October 31, 2024

Subject: Trails at Aspen Ridge Filing 1
Roadway Repair Recommendations
Colorado Springs, Colorado
Project No. 22.141

During a meeting on October 16, 2024 between representatives of El Paso County Department of Public Works, Colorado Land Acquisition (COLA), and CMT Technical Services - Colorado (CMT), proposed repairs to areas of utility trench settlement within the roadways of the subject development were discussed. CMT was requested to provide a summary of the proposed repairs. The purpose of this letter is to summarize CMT's recommendations.

BACKGROUND IMAGE FROM NEARMAP, DATED APRIL 17, 2024.

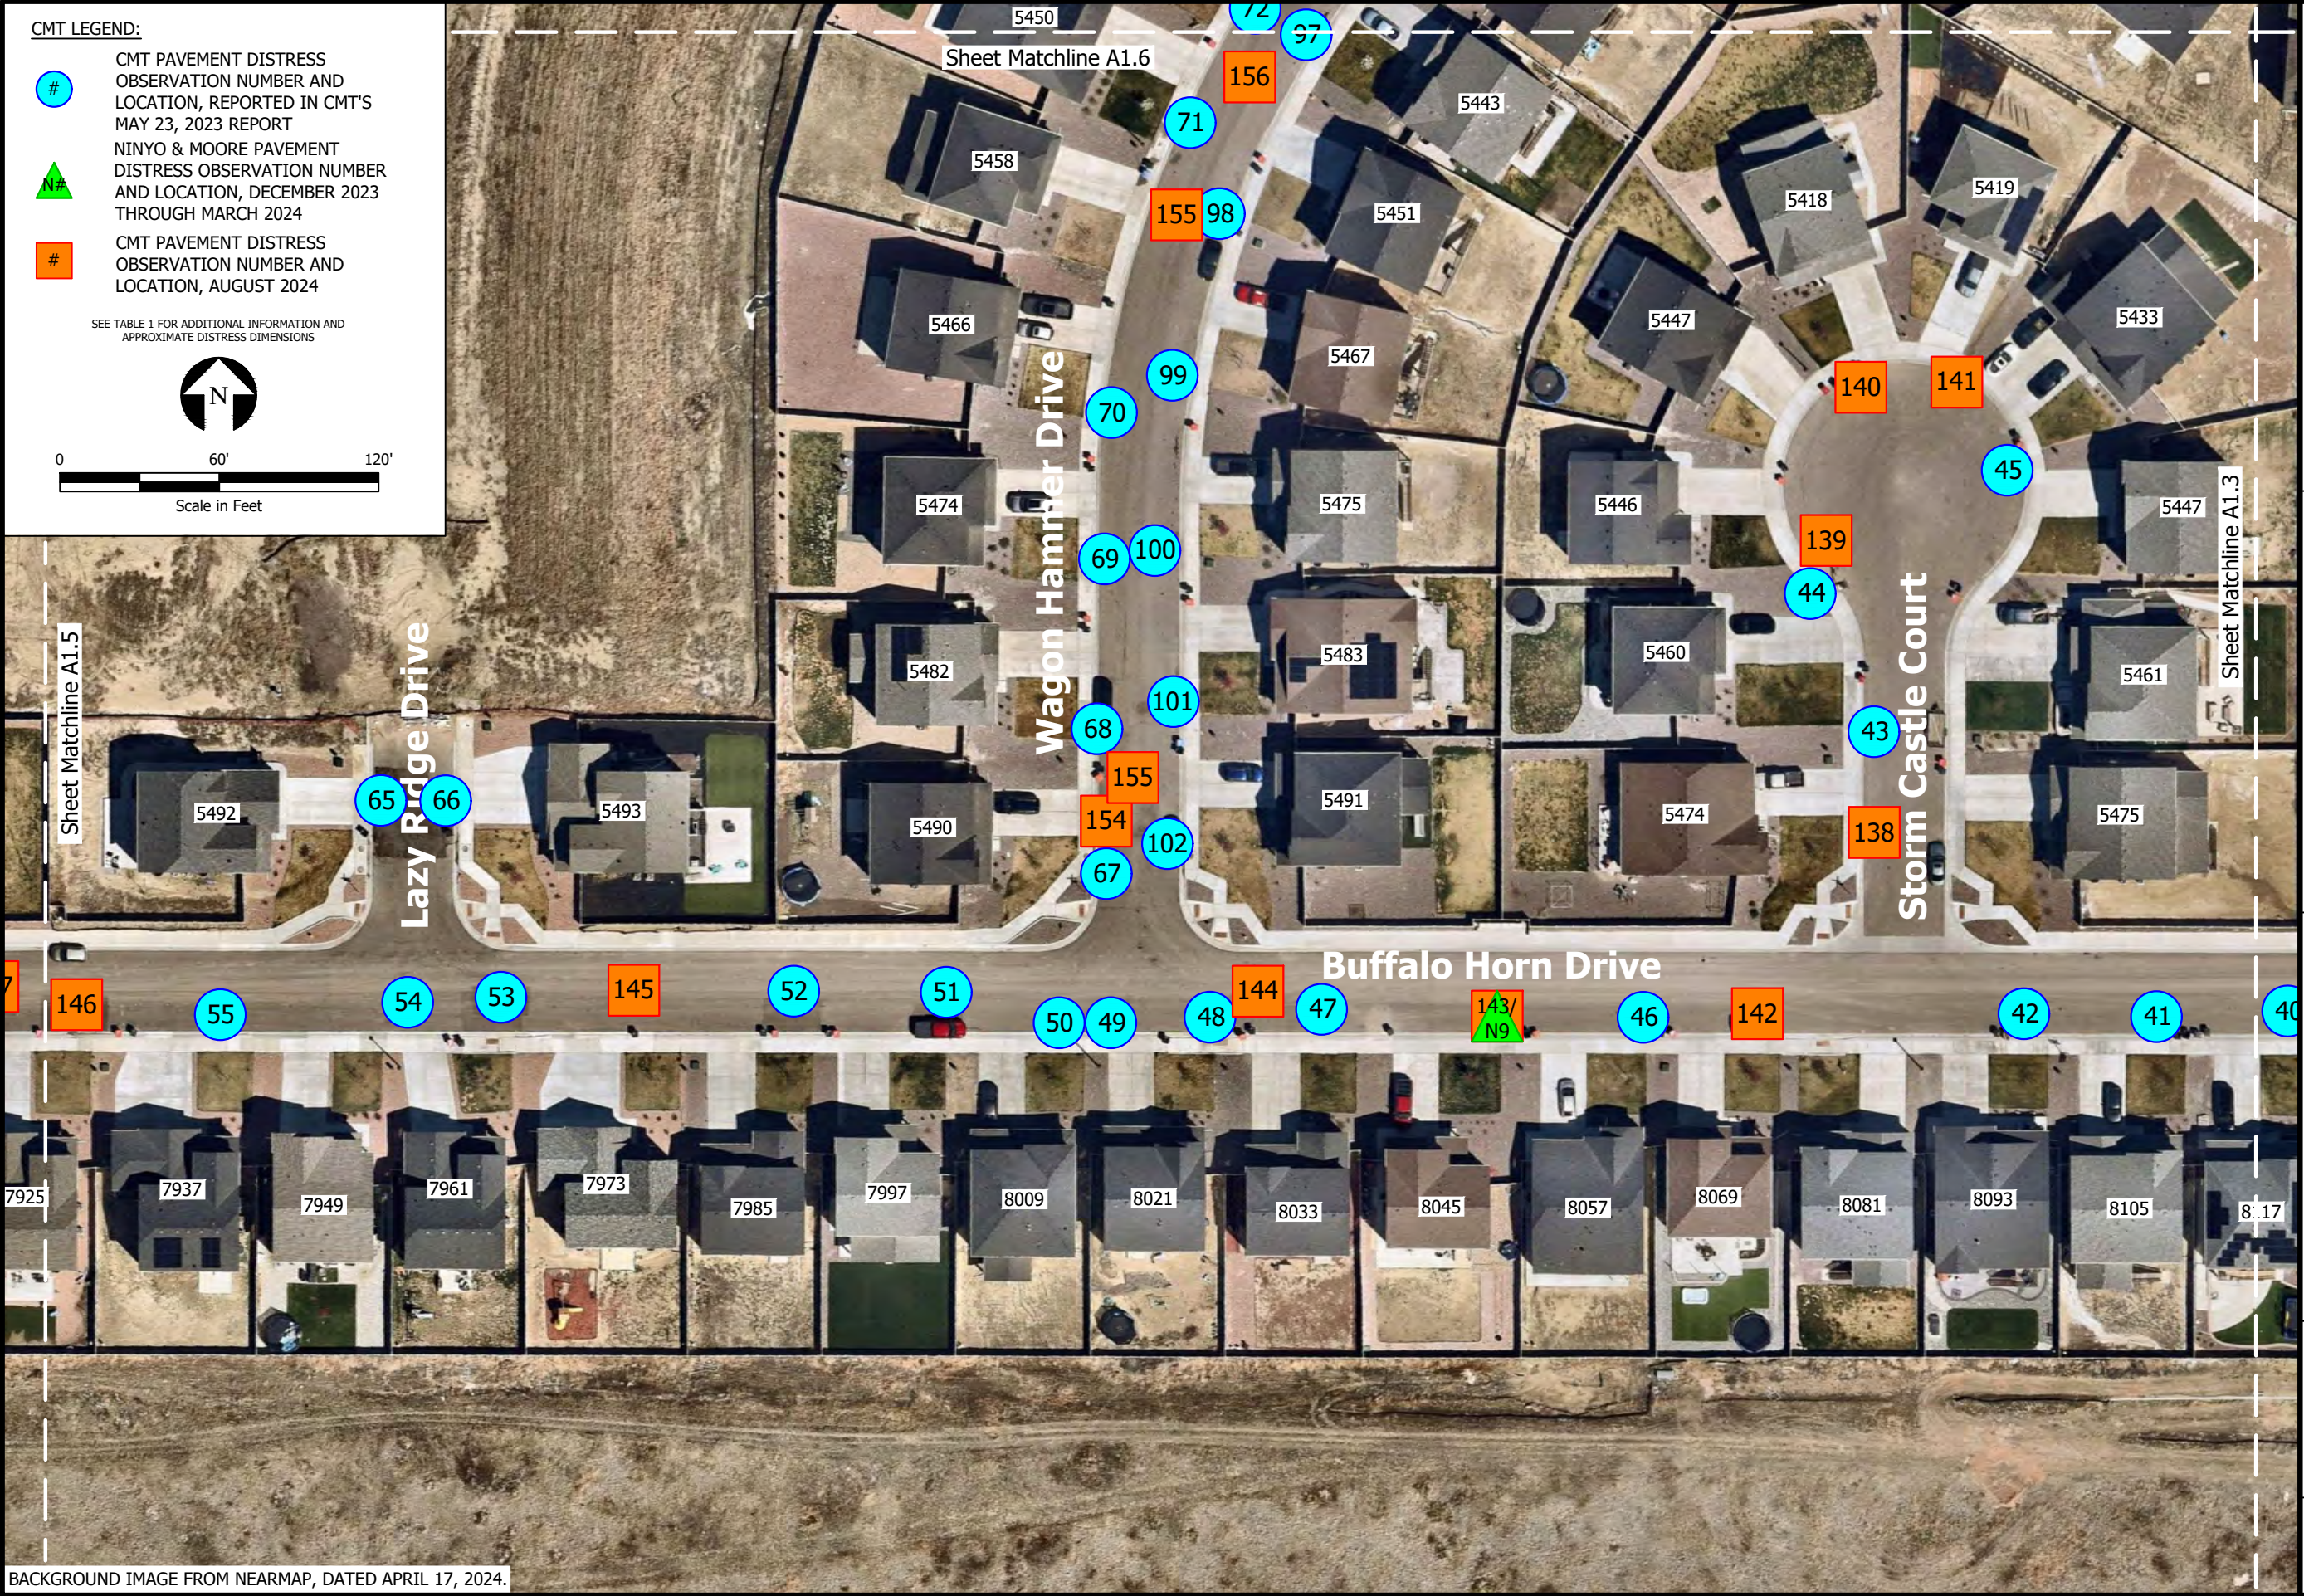
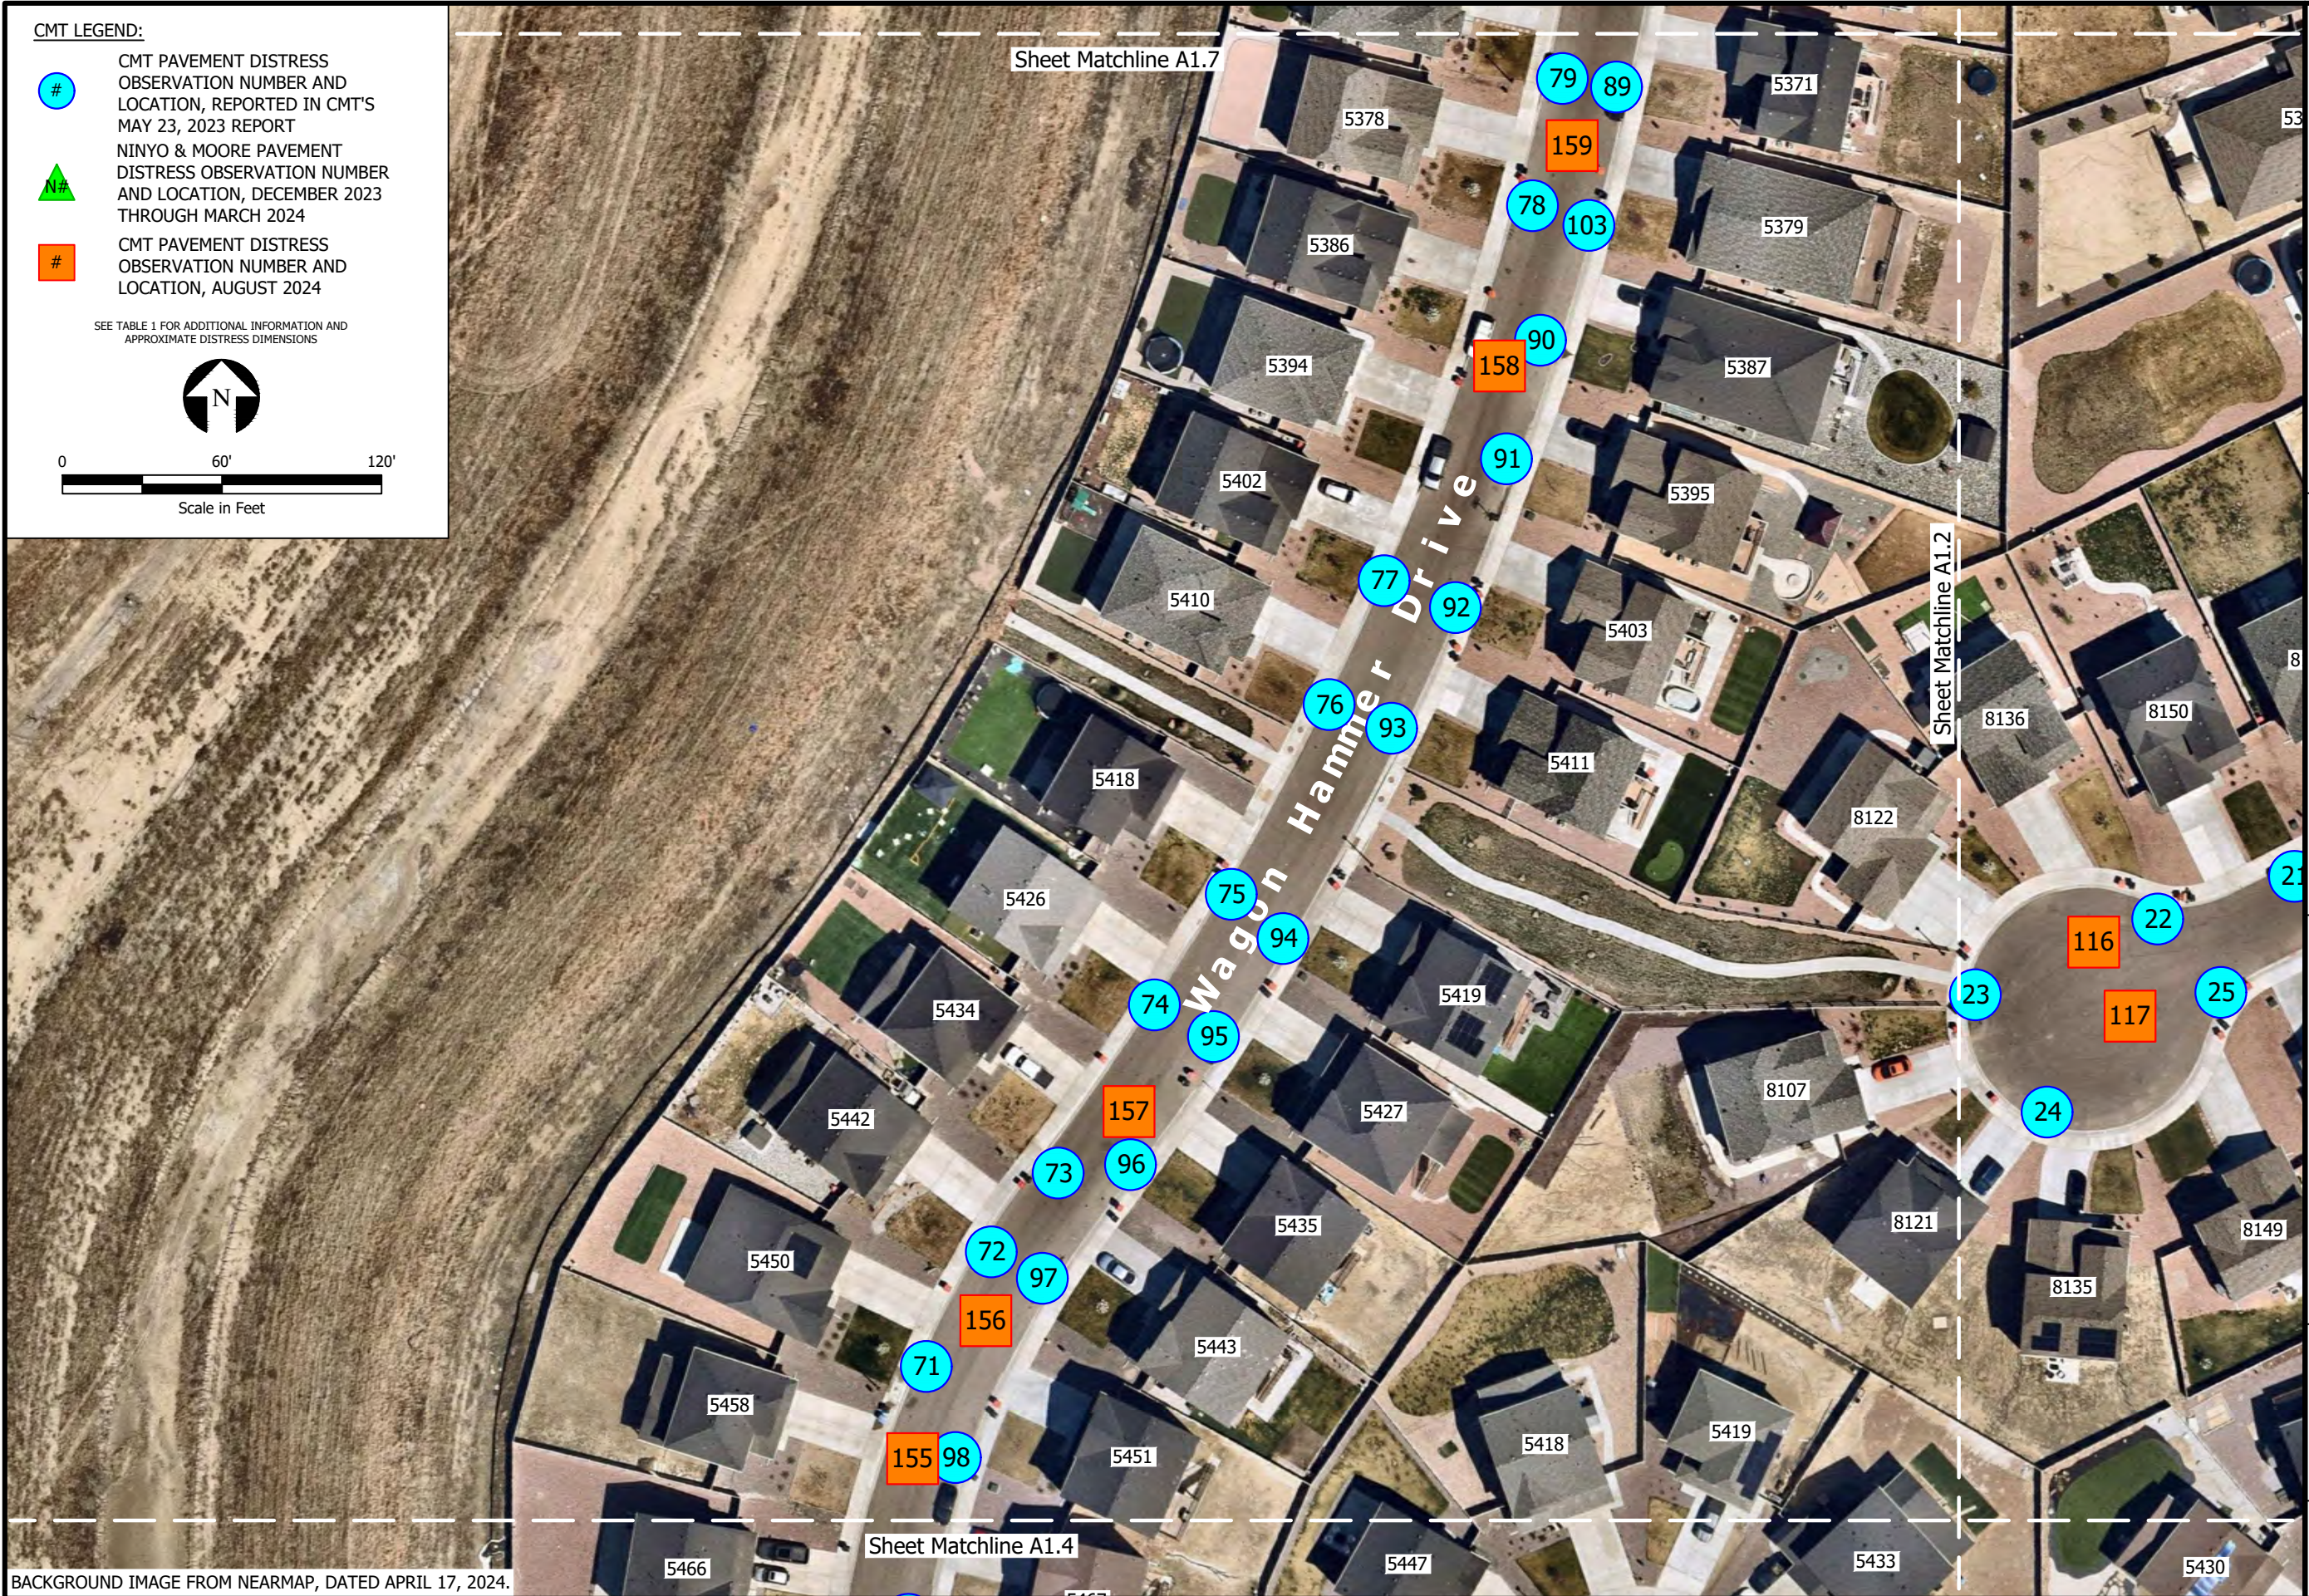
CMT performed observations in November 2022 and August 2024 to observe and document existing distress. CMT's observations are summarized in Tables 1 and 2 and Figures A1.0 through A1.7, appended.

CMT observed that the number of distress locations increased, the severity of previously existing distresses increased, and distress within the mainline trenches had developed during the time period between CMT's November 2022 and August 2024 observations. CMT initially recommended performing isolated excavations where settlement had occurred within the service lateral trenches. The existing extent of distress does not allow for isolated repairs at laterals for a majority of the roadways in Filing 1. There are isolated sections of roads where the distress is still limited to the laterals and isolated repairs at laterals are still recommended. The locations where isolated excavations are recommended include:

- Big Johnson Drive.
- Falling Rock Drive.
- Eastern cul-de-sac of Buffalo Horn Drive.
- Storm Castle Court.
- Wagon Hammer Drive between addresses 5402 and 5426.
